**PAD-2**  
PADMARK BUSINESS PARK-LOT 2-1  
1150 MEADOWBROOK PKWY  
COLORADO SPRINGS, CO 80915  
EL PASO COUNTY, COLORADO

1 of 10  
SITE PLAN

PCD File No. PPR-18-020

1 SITE PLAN
SCALE: 1"=30'-0"

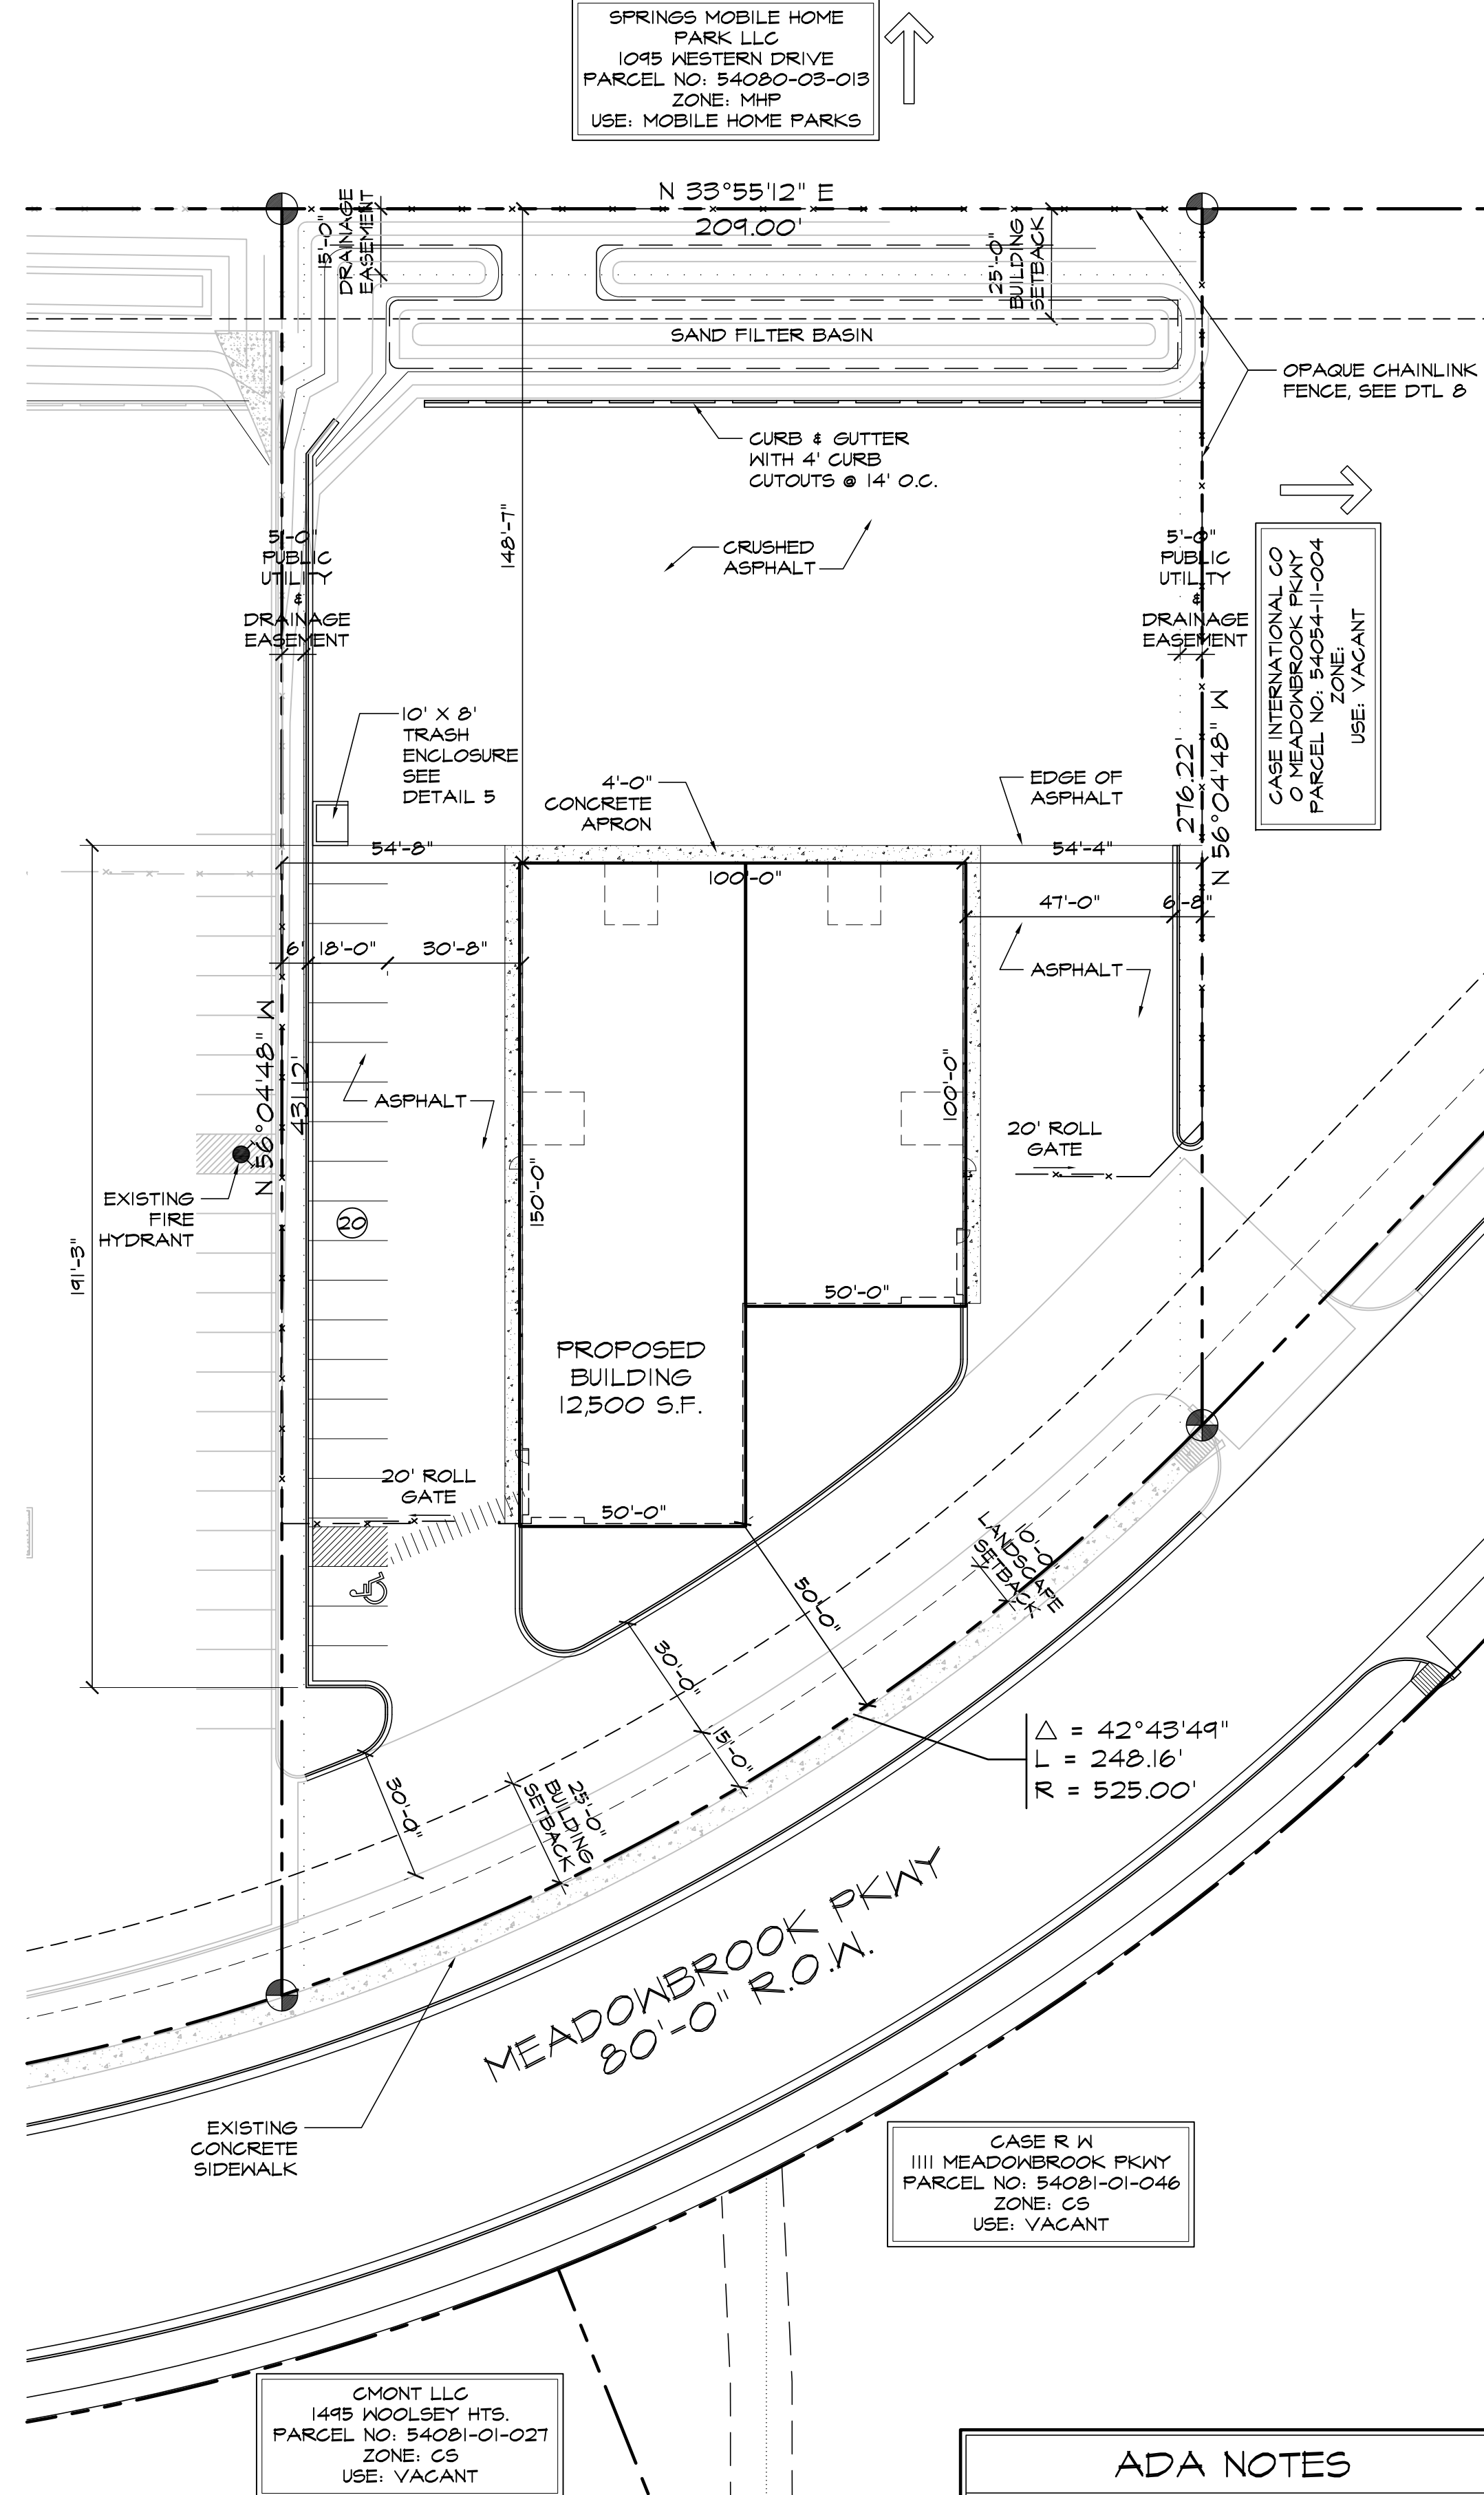
ADA Route to building entrance required to be shown on map from handicap parking spot,.

Must have this note :  
The parties responsible for this plan have familiarized themselves with all current accessibility criteria and specifications and the proposed plan reflects all site elements required by the applicable ADA design standards and guidelines as published by the United States Department of Justice. Approval of this plan by El Paso County does not assure compliance with the ADA or any regulations or guidelines enacted or promulgated under or with respect to such laws.

Show and label the easements
